R O N A L D L . K N O T T , P . E .

Nov 25, 2019

RE: Engineering Review of Footing Offset and Size for 76 Virginia Lane, Cameron, NC

FOUNDATION PLAN

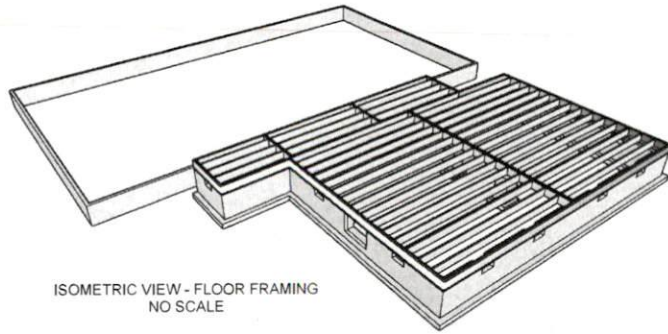
I reviewed the as-built condition of the new footings adjacent to the existing foundation curtain wall. The new piers are 16"x16" and the concrete footings extend beyond the piers in all directions.

The size and projection of these footings are adequate for code required loading conditions for this application.
